Memorandum

Project:	Waterville Street Condominiums	Project No.	0111
Date:	August 15, 2003		
To:	Mr. Michael Nugent Inspection Services Manager City of Portland City Hall Room 315 389 Congress Street Portland, ME 04101	Phone No.	(207) 874-8700
		Fax No.	(207) 874-8716
From:	Will Tinkelenberg TFH Architects	Phone No.	(207) 775-6141
		Fax No.	(207) 773-0194
Re:	Review Comments	Copy to:	File

We offer the following in response to your review comments of August 13, 2003:

MODIFICATIONS SUMMARY  
△ CEILING HEIGHTS IN BATHROOMS  
REDUCED  
△ COLUMN REPLACED WITH 6" STUD  
WALL TO ACCOMMODATE PLUMBING

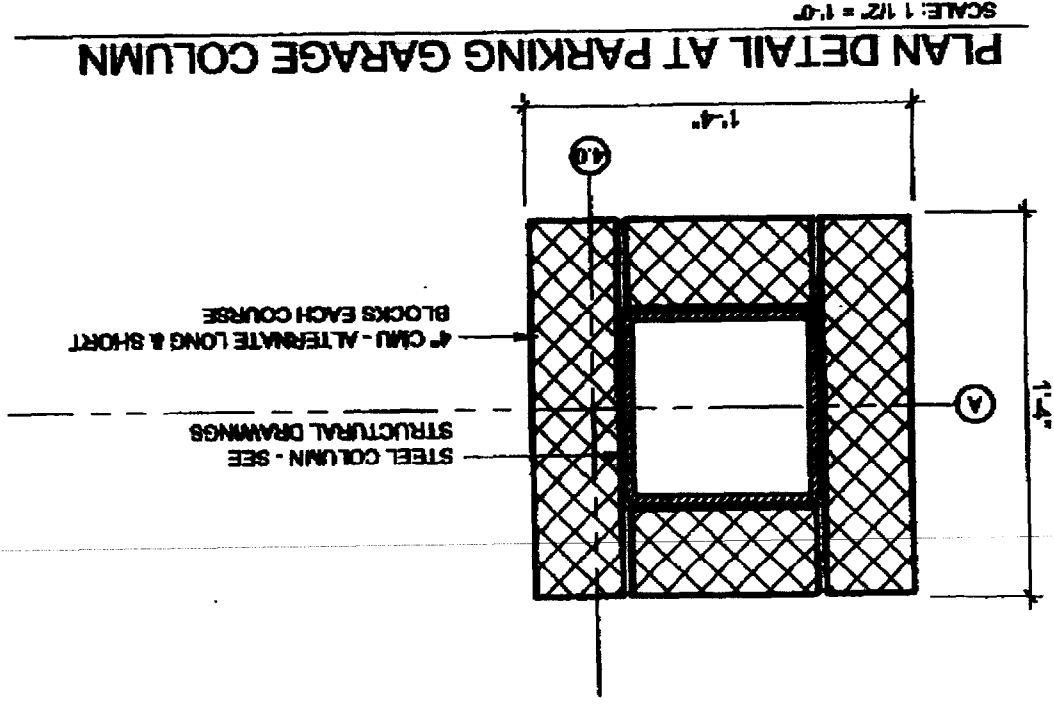
- 1.) We have added a note to Building Section 2 on A3-1 (Page 3) which should address your concerns. What was originally a post on Line 6.0 at the corner of the Kitchen counter was changed to a wall; see SK-6, included here (Page 4). Also included here is a plan detail for the column in the Parking Garage (Page 5).

# A1-3

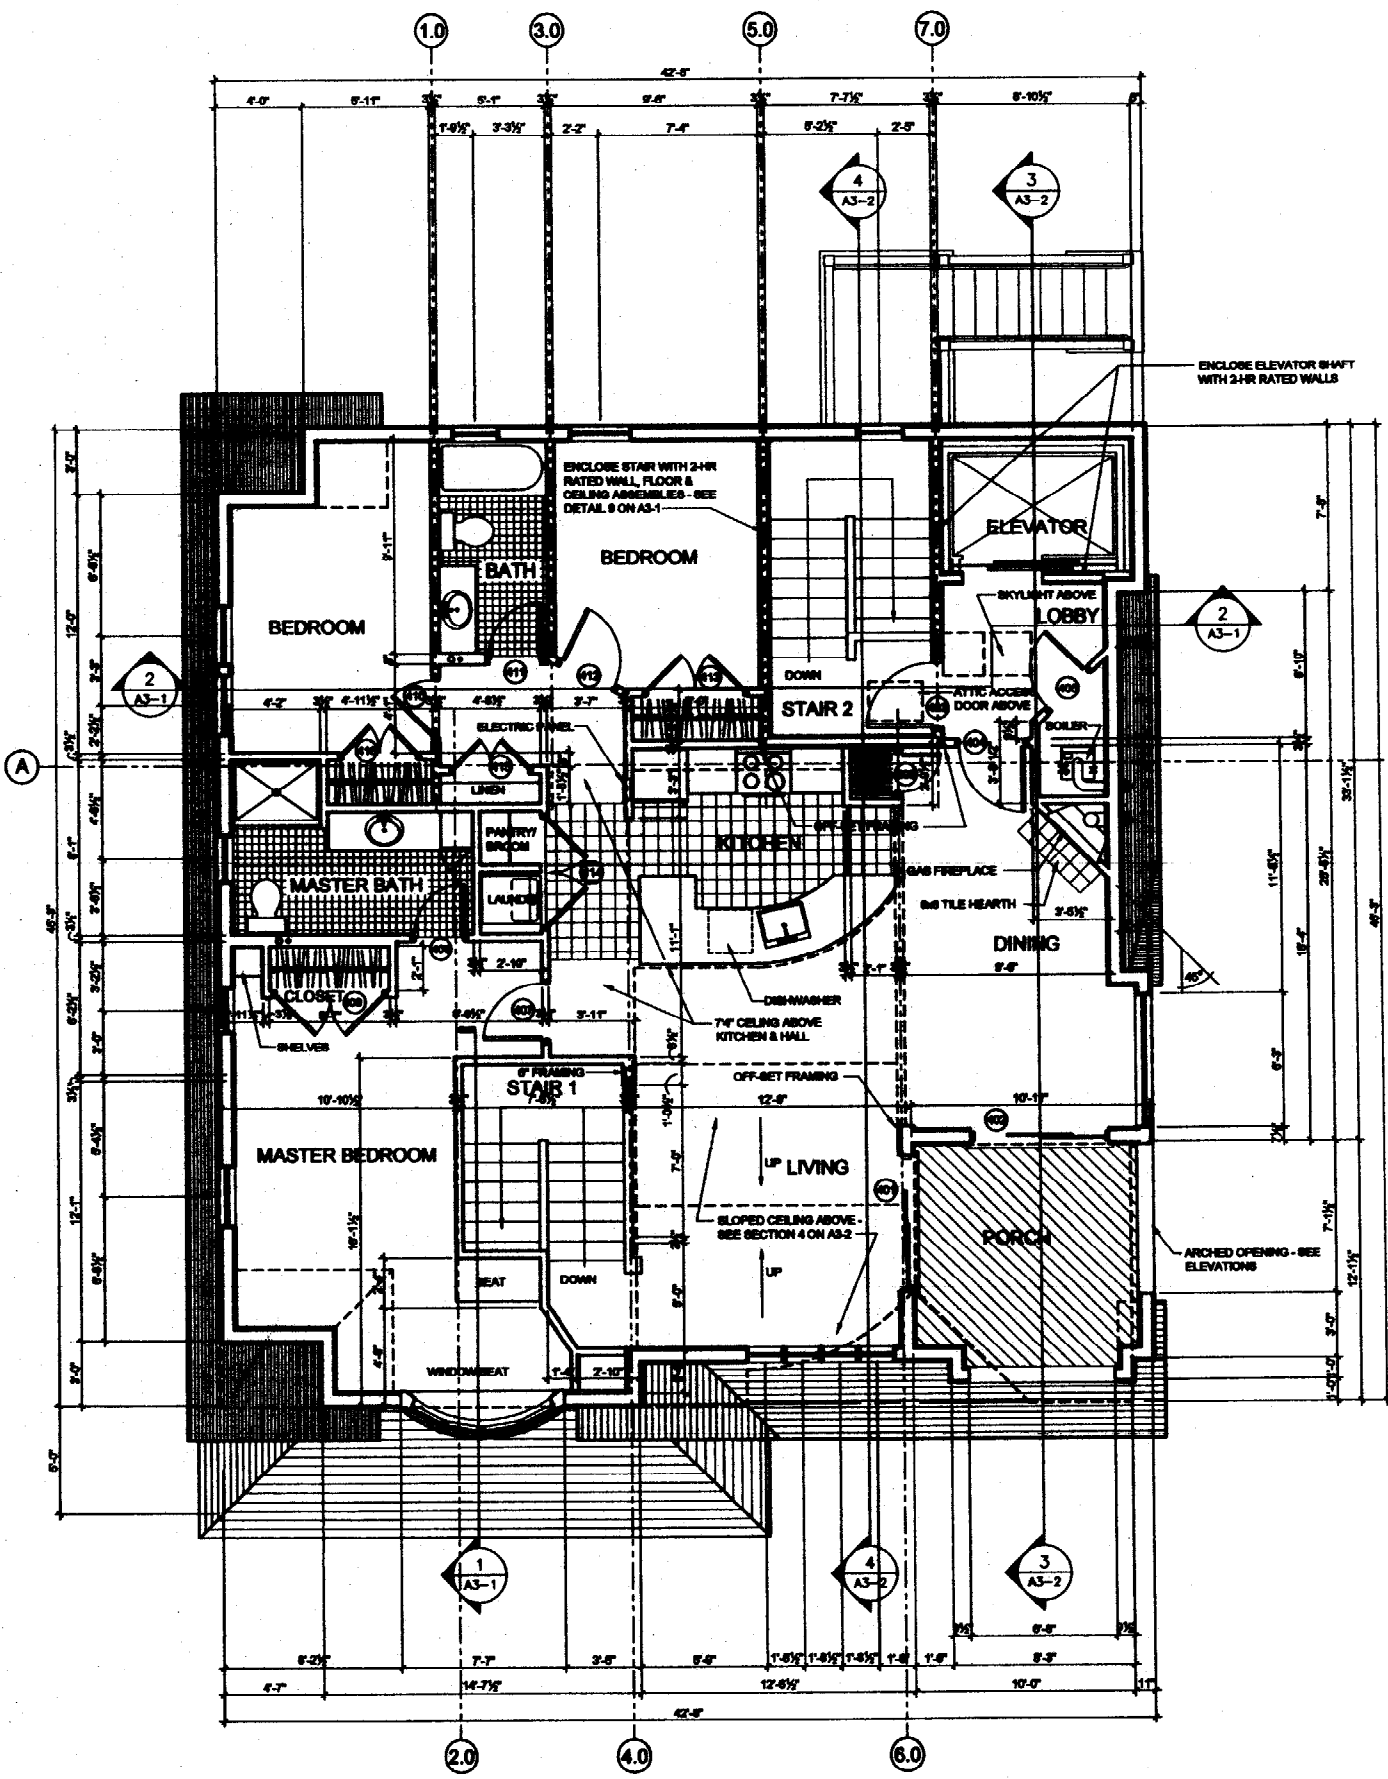
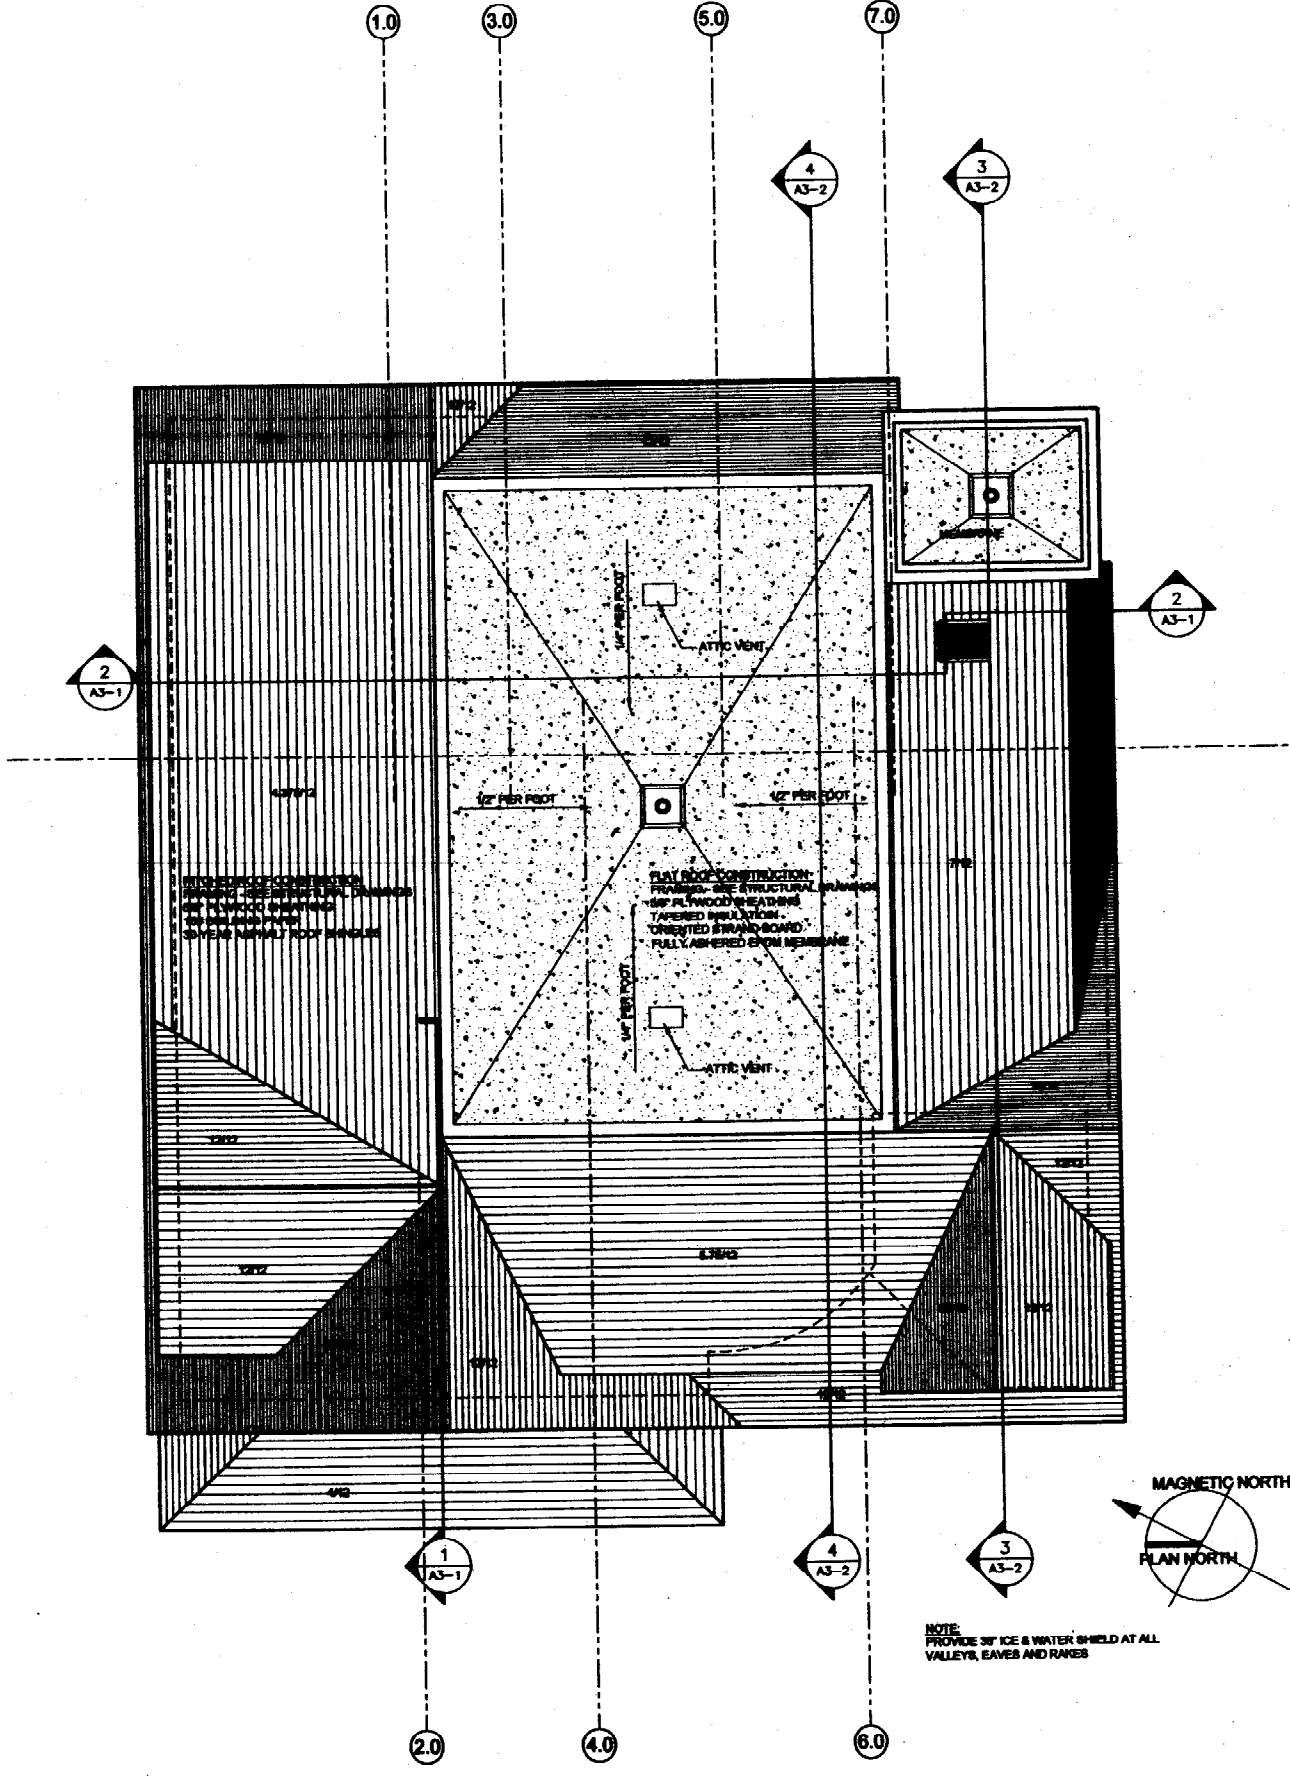
- 2.) Roof access is provided through a rated Attic Access Door in the ceiling of Stair 2 (See Fourth Floor Plan on A1-3).
- 3.) The Fire Department Connection will be located on the left side of the building near the front; we have added this to Drawing M1-1 (See Page 3).
